From: Richard Stefanski [REDACTED]
Sent: 16 February 2021 13:12
To: Simon Davis <Simon.Davis@arun.gov.uk>
Cc: Alex Burrows [REDACTED]
Subject: RE: BR/8/21/RES

Subject: BR/8/21/RES

GROUND FLOOR PLAN

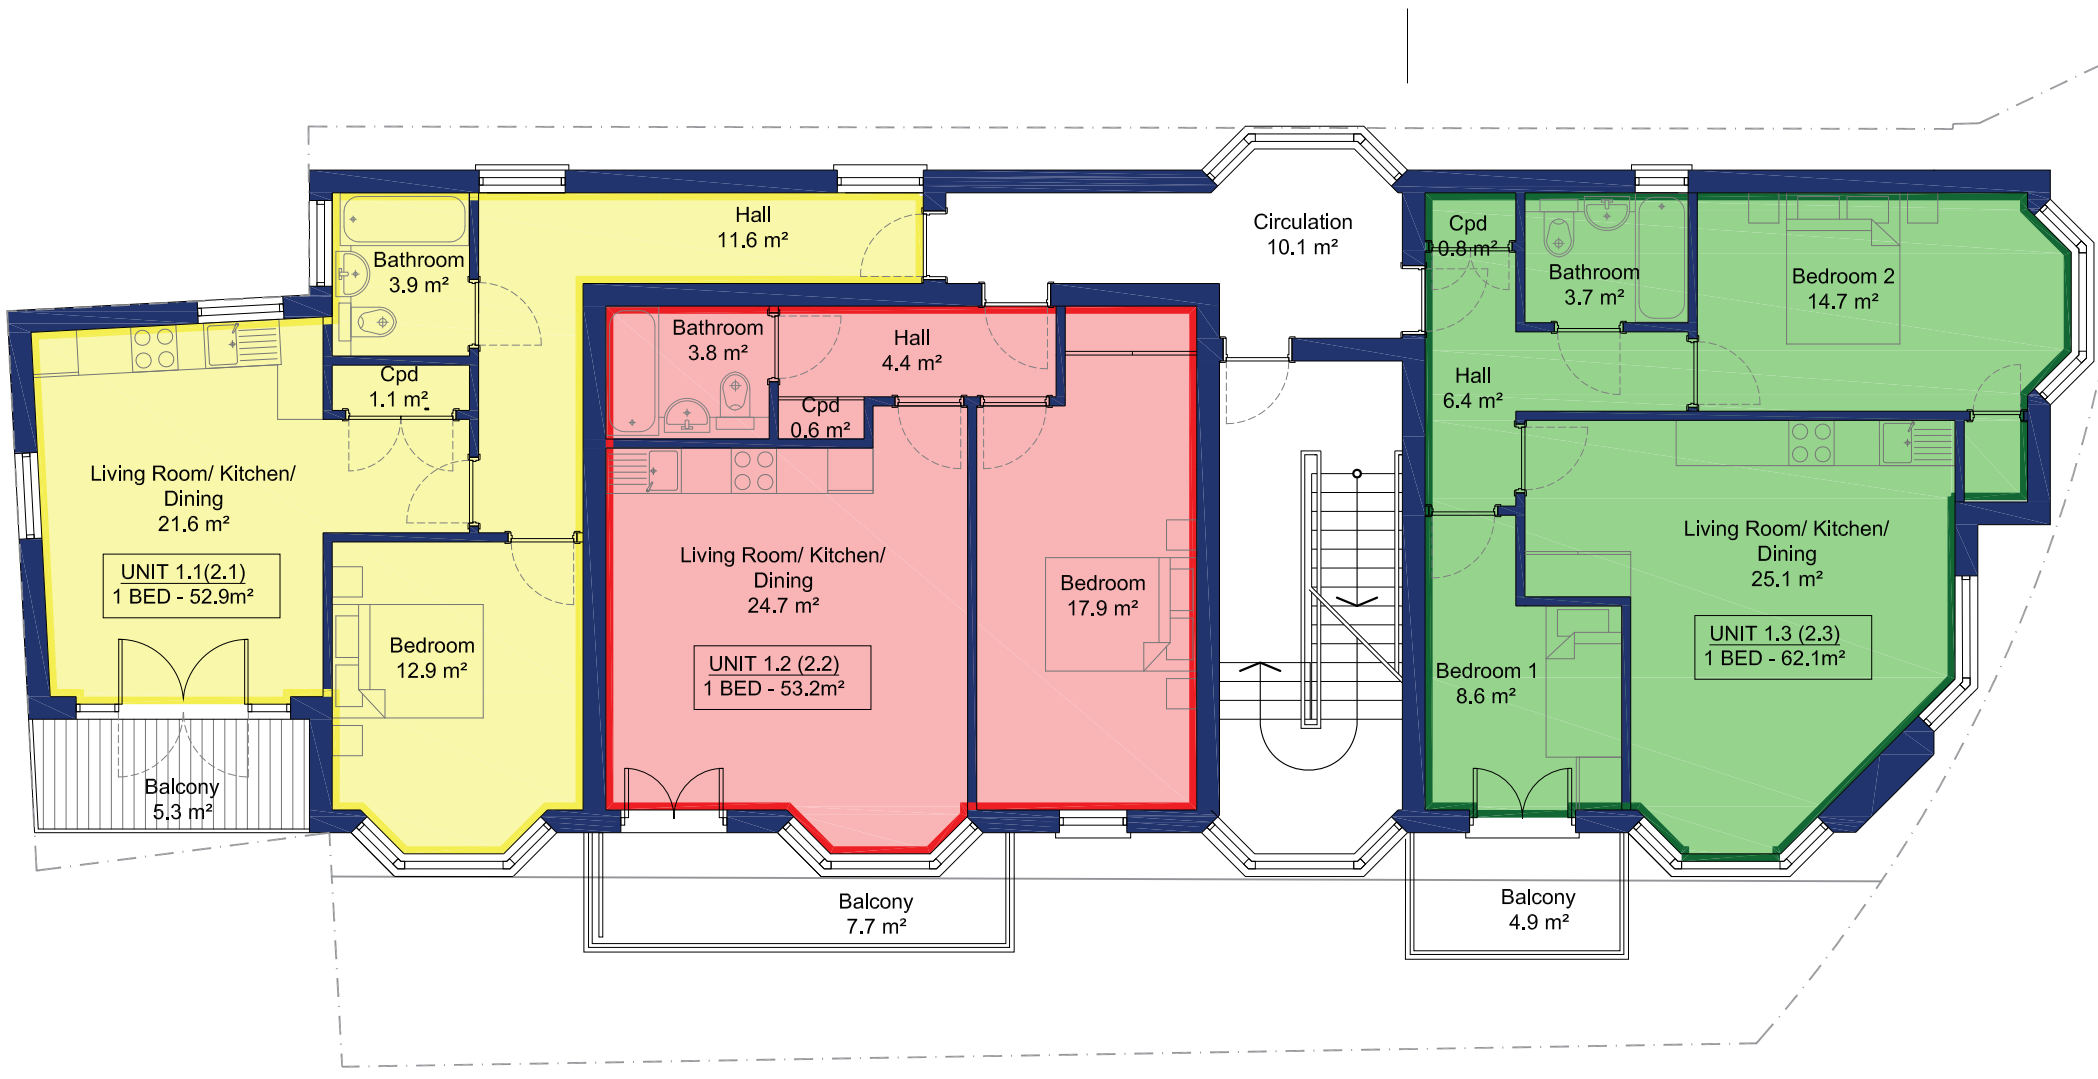
With reference to Environmental Health's comments on the original application (BR/142/18/OUT), Environmental Health objects to this application as the layout has habitable rooms facing the railway which will mean that BS8233 will only be met if the windows are kept closed. This application therefore does not follow the principles of good acoustic design within ProPG.

Please note that this was raised at the outline stage and indeed formed part of an informative 12 on the decision notice. I therefore write to request that you amend the floor plans/building layout to remove habitable rooms from the elevation backing onto the railway line. Please provide amended plans by the 17th February or if you need longer, advise me when you need until.

Unit G.1

- Floor plan revised. Adjusted from a 5-person 3 bed to a 4-person 2 bed.
- Window located in the living/kitchen dining, along the north west elevation, kept fixed shut, standard thermal double-glazing (which provides a sound reduction of RRAIL = 36dB) will be sufficient to ensure compliance with the requirements of BS8233 for daytime and night time periods. The room benefits from openable windows along the south east elevation. The windows are large enough to provide adequate purge ventilation.
- Bedroom 1 & 2 are located, with openable windows along the south east elevation.

It should be noted that the attached design, in most cases, uses buffer-zones to protect habitable rooms. The buffer-zone is created using bathrooms, utility, kitchens, and halls. They are used in this design on the most exposed elevation. In addition, further to this recent adjustment, no bedrooms have windows within the north west elevation.

PROPOSED NORTH-WEST FACING ELEVATION

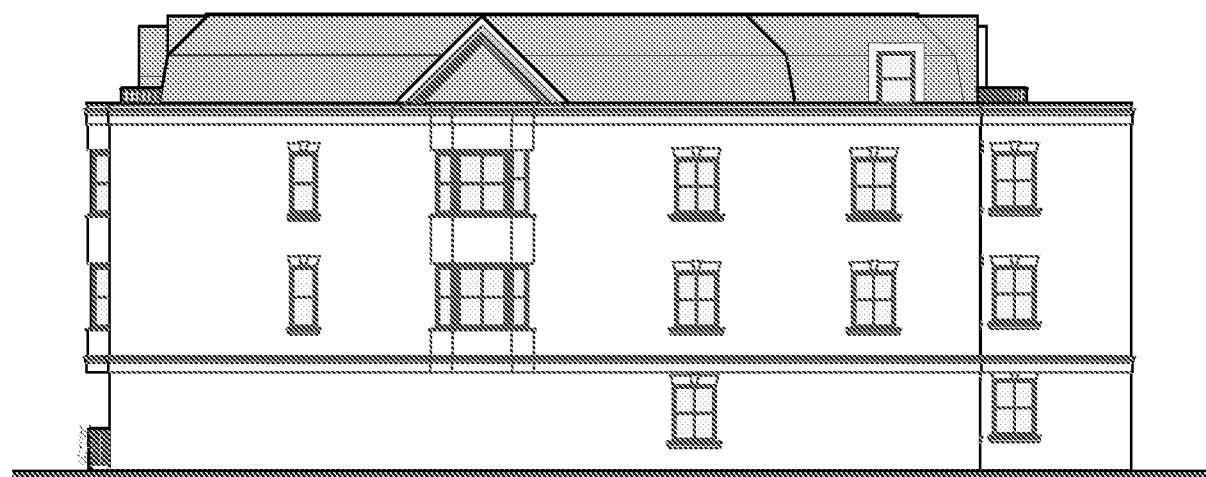
As regards the question of the change to the NW elevation, I have looked back at the photos I took in late 2018 and I see that there is already quite a contrast between that elevation and the render on the rest of the building. I have no objection in principle to brick but please achieve as much of a similarity as you can. For example you could use white painted brick or I have just seen on Google that you can buy white bricks without painting them.

Whilst writing, we have concerns regarding the render on the north west elevation. We would like to discuss a brick finish on this elevation for maintenance, and aesthetic purposes. We are keen to have a building that looks good throughout the year, render in this location is hard to maintain.
